**Consultation Response from KC,
Highways Development Management****2024/90137 adj, 18, Ullswater Close, Dewsbury, WF12 7PN****Outline application for erection of 1 dwelling****Date Responded: 21/03/2024.****Responding Officer: D. Stainsby****Responding Ref: K15/8SW-25**

This outline application is for the erection of a detached dwelling adjacent to 18, Ullswater Close, Dewsbury.

Proposed Site Plan

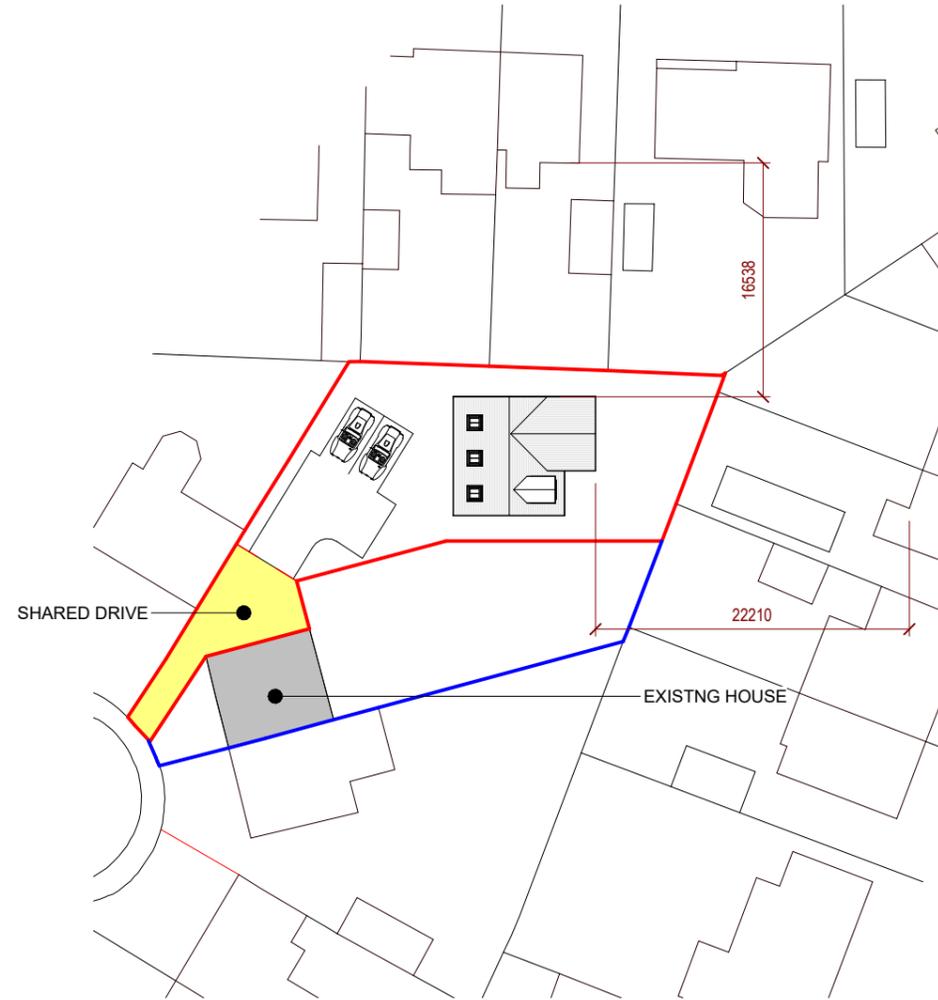
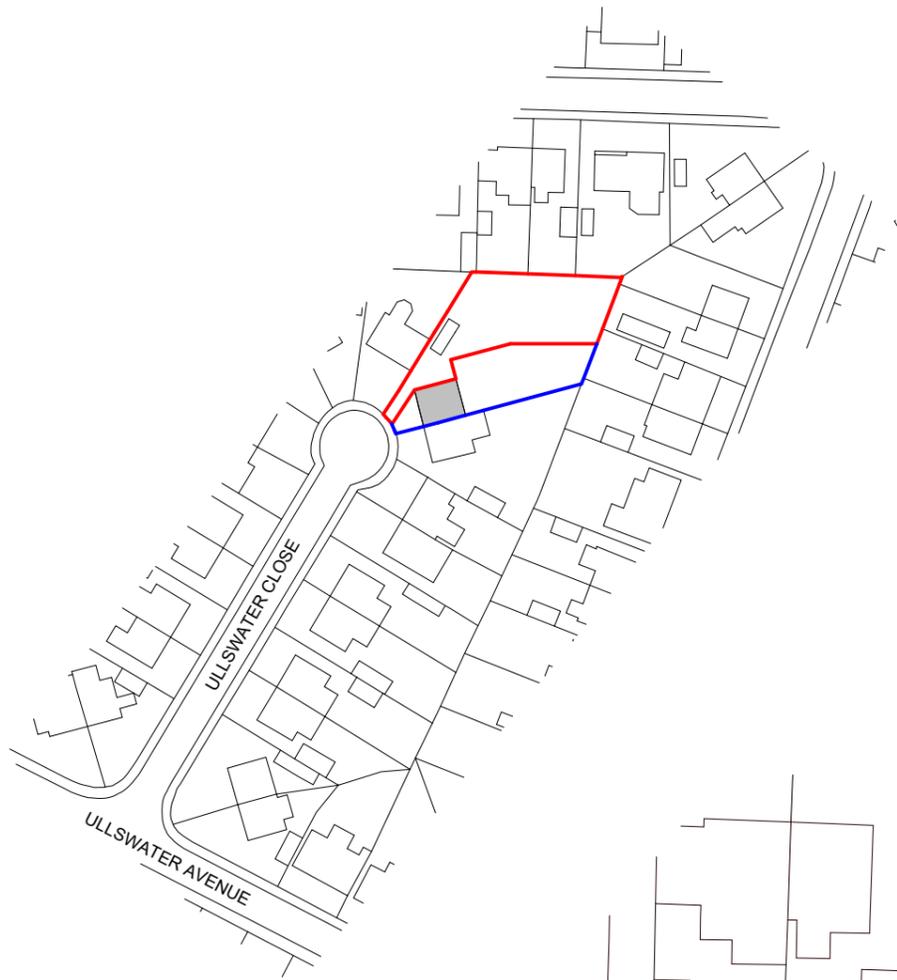
Objection. Highways Development Management could not support the application as submitted. The site layout does not satisfactorily demonstrate that sufficient parking, turning and manoeuvring space would be available to serve both the existing and the proposed dwelling.

The proposed driveway width at 2.3m is substandard.

The Kirklees Highway Design Guide states that to ensure residents can access their properties, a private drive serving five dwellings or fewer should be a minimum of 4.5m wide (5.0m wide if there are structures along its initial length for example walls) for the first 5.0m of its length. This will allow vehicles to turn in and turn out.

Even for a single dwelling a driveway should be at least 3m wide, or 3.3m if the drive provides the main pedestrian access to the dwelling.

The Applicant has stated that four parking spaces will be provided. Two parking spaces for the proposed dwelling and two spaces for the existing dwelling.

The parking spaces for the proposed dwelling are acceptable. However, the parking spaces for the existing dwelling will use the shared access, effectively blocking the access to the new dwelling.

No bin storage areas are shown for either the existing or the proposed dwelling.

A waste collection/presentation point adjacent to the public highway will be required for the new dwelling due to the length of the driveway being over the recommended carry distance.

- A revised drawing showing that the driveway can be widened to a minimum of 4.5m needs to be provided.
- A revised drawing showing that 2 car parking spaces for the existing dwelling can be accommodated within the site curtilage without obstructing the access needs to be provided.
- A bin storage area within the site, together with a bin collection/presentation point, needs to be identified.

Two parking spaces for the existing dwelling will need to be provided in an area that does not obstruct the shared access.

Details of waste storage and collection for both dwellings should be provided.

The bin collection/presentation point should be located adjacent to the public highway. The bin collection/presentation point must not obstruct the adopted highway or the access road for road safety reasons.
